2023/0793

Variation of condition 2 (approved plans) relating to application 2019/0577 to enable changes to the window arrangements on the Edinburgh house type (9no plots) -Demolition of vacant former hospital buildings and residential development of 70 no dwellings and associated works.

Former Mount Vernon Hospital, Mount Vernon Road, Worsbrough, Barnsley

Mount Vernon Road, Barnsley - Site Sections

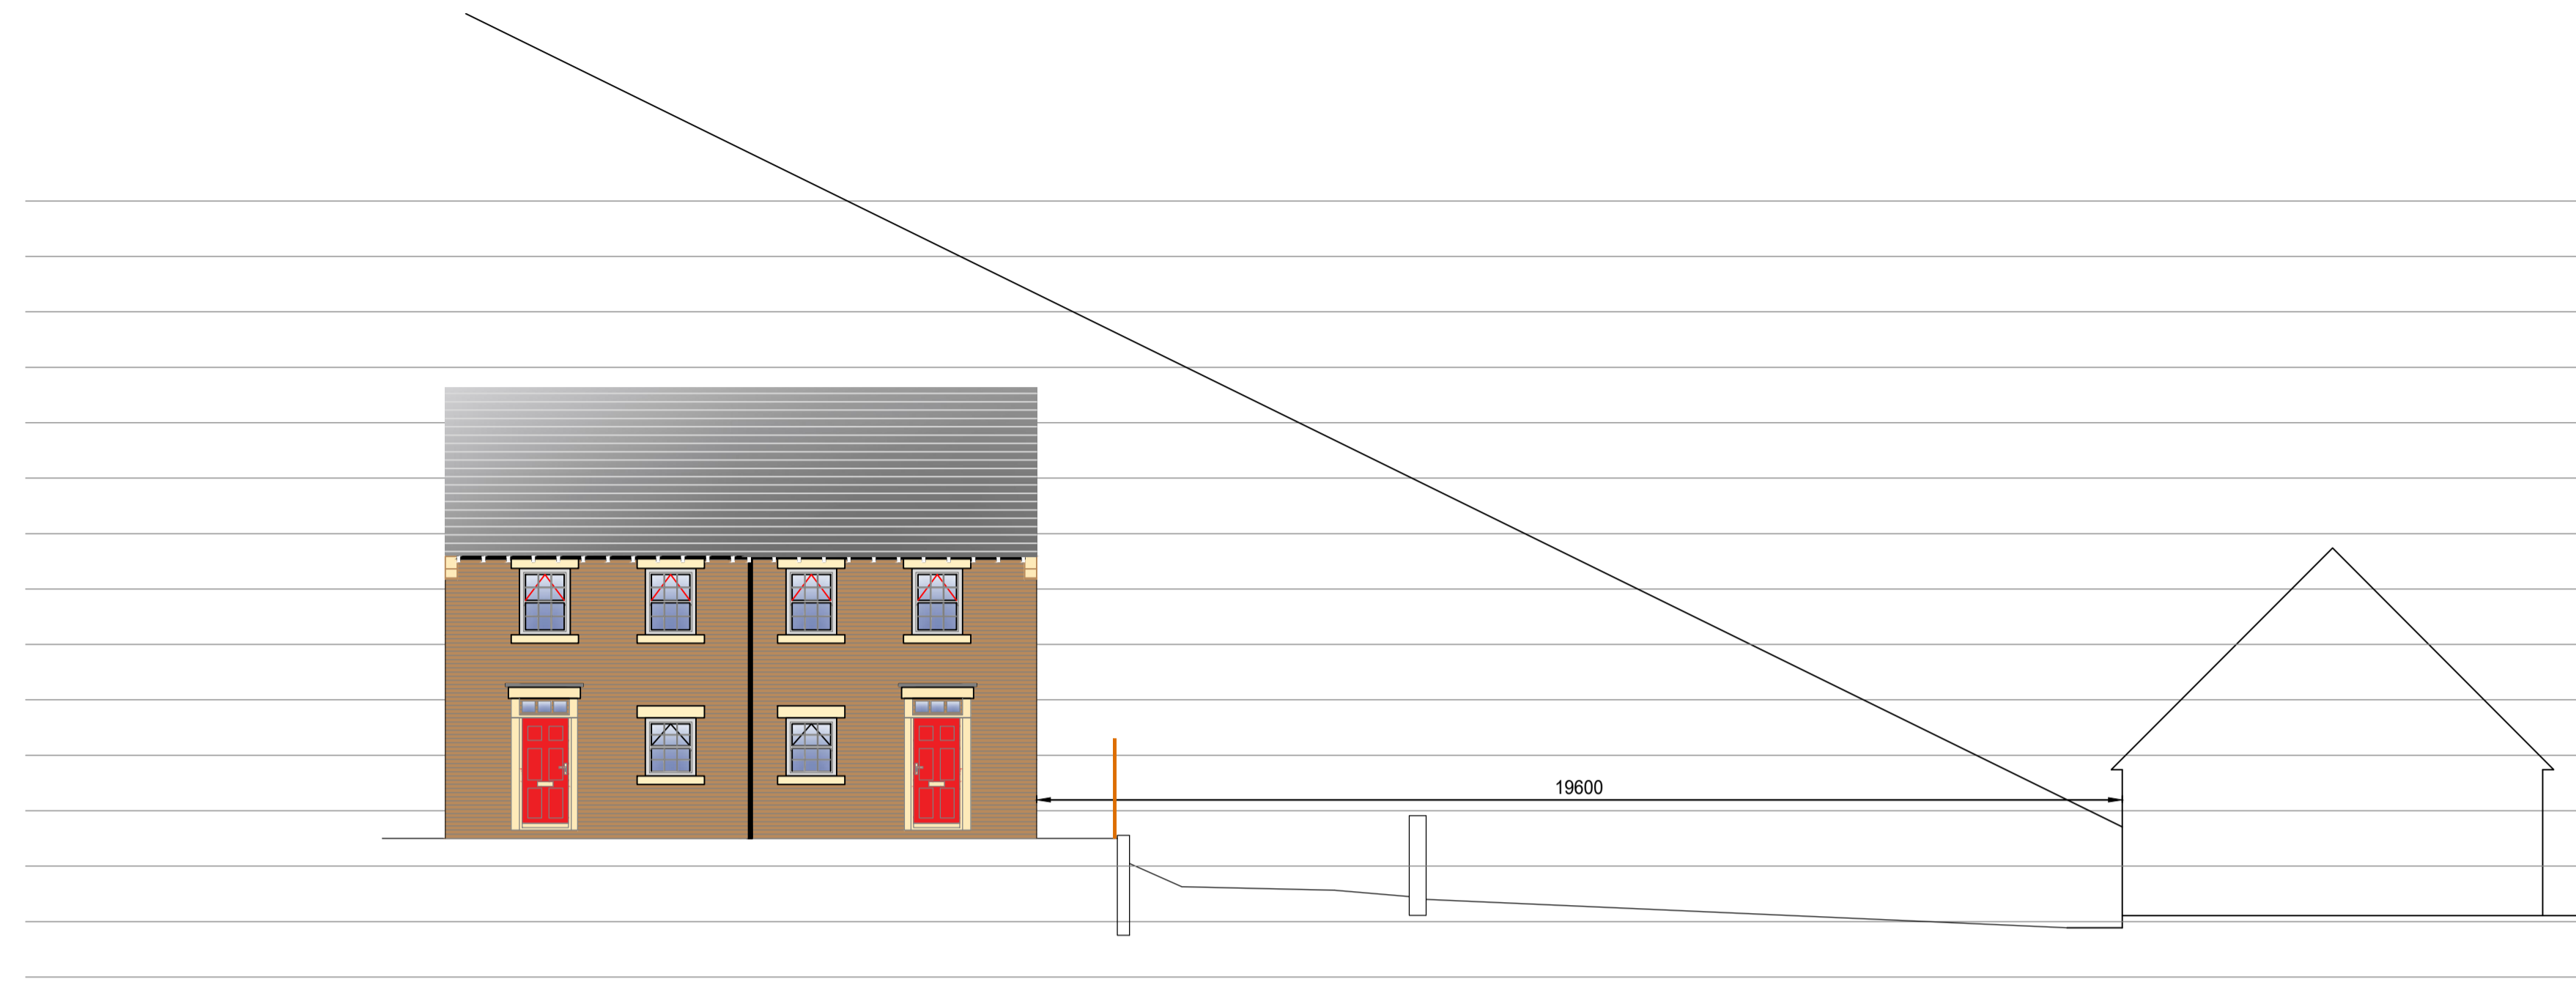
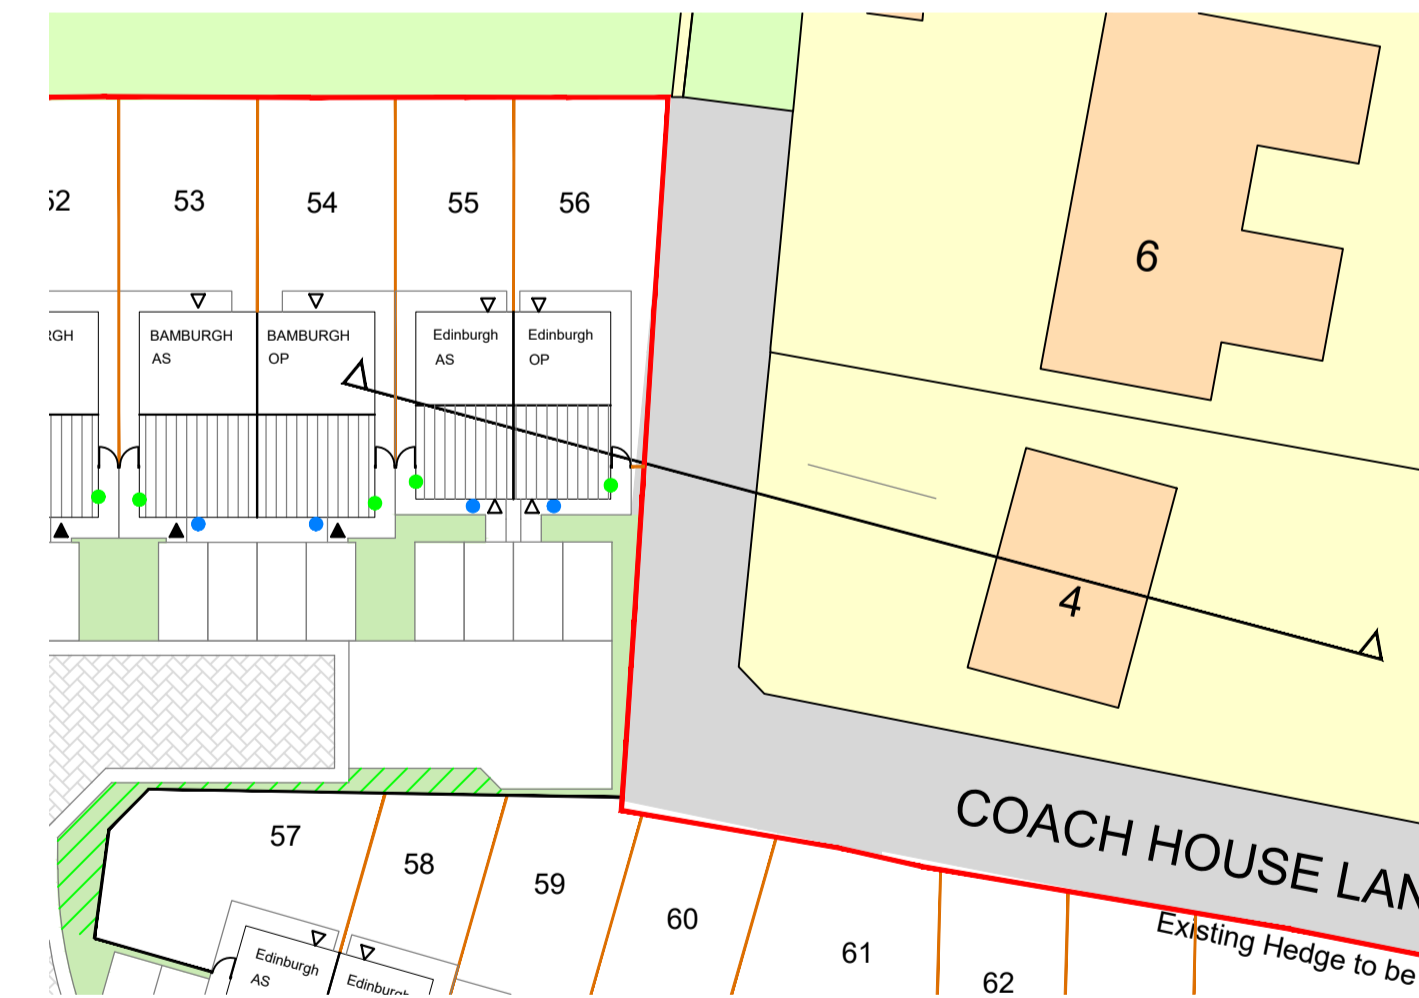
Clarification was also sought in relation to the boundary treatment along the eastern boundary of plot 56 following concerns raised by neighbours. It is acknowledged that a 1.8m hit and miss timber fence located on top of the retaining wall could potentially lead to a loss of outlook. However as mentioned previously, the plans submitted clearly indicate that the location of the boundary far exceeds the minimum distances set out in the SPD and as such would therefore not result in a loss of outlook.

Comments have been made in relation to a change in levels. Whilst plot 56 lies at a slightly higher level than the properties on Coach House Lane, this was considered and approved by councillors when application 2019/0577 was considered and approved. There is no evidence to suggest that the levels of plot 56 have been raised above the levels approved.

Project:	The Edinburgh - Planning (mid)
Drawing Number:	2020/2014
Revision:	-

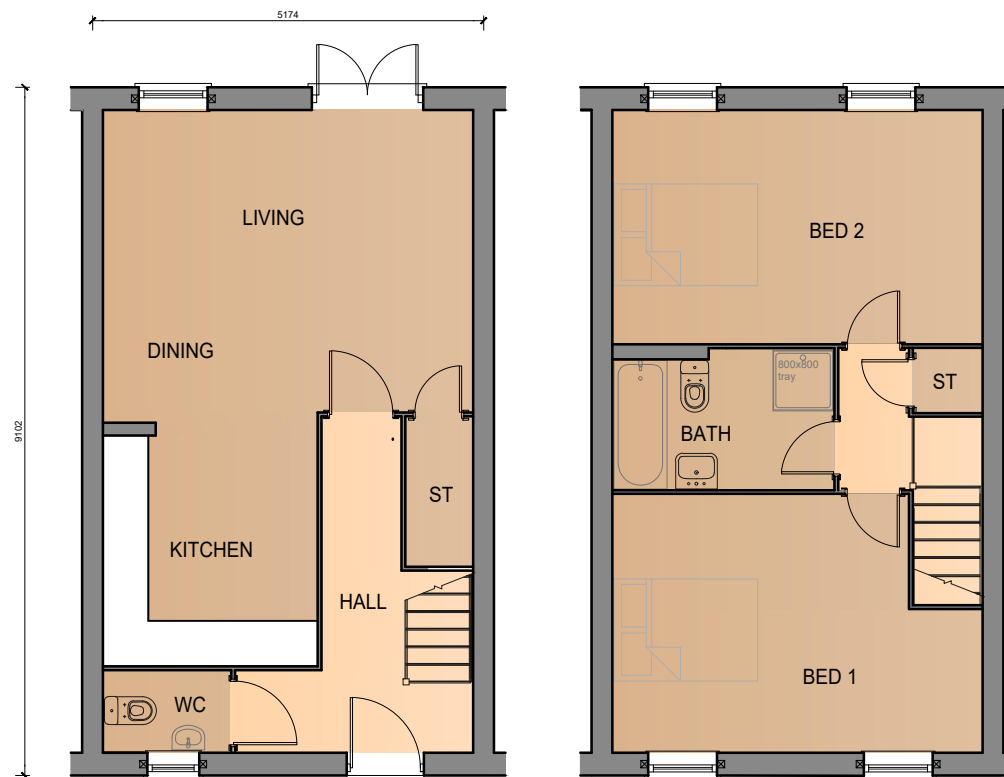
The Edinburgh house type was originally approved with no windows on the side elevation with it now being proposed to include 1no window at ground floor level and 1no window at first floor level serving the open plan kitchen/dining/lounge and bathroom respectively due to changes to the internal layout.

It is acknowledged that the changes to the Edinburgh house type would result in the inclusion of 2no additional windows on the eastern elevation of plot 56 which would face the rear elevations of the 4 and 6 Coach House Lane, which could potentially lead to an

increase in overlooking. However, the ground floor window would be a secondary window serving an open plan kitchen/dining/living area. The hit and miss timber fence installed along this boundary would provide adequate screening to prevent an increase in overlooking of the properties beyond. The first-floor window would serve a bathroom which is not classed as a habitable room and would have obscure glazing to protect amenity of the occupiers of plot 56. Supplementary Planning Document – Design of Housing Development (SPD) outlines the minimum acceptable separation distances between dwellings. The plans submitted clearly indicate that the location of the additional windows far exceed the minimum distances required by the SPD, and in addition plot 56 and the existing dwellings are separated by Coach House Lane and as such would not result in an increase in overlooking.
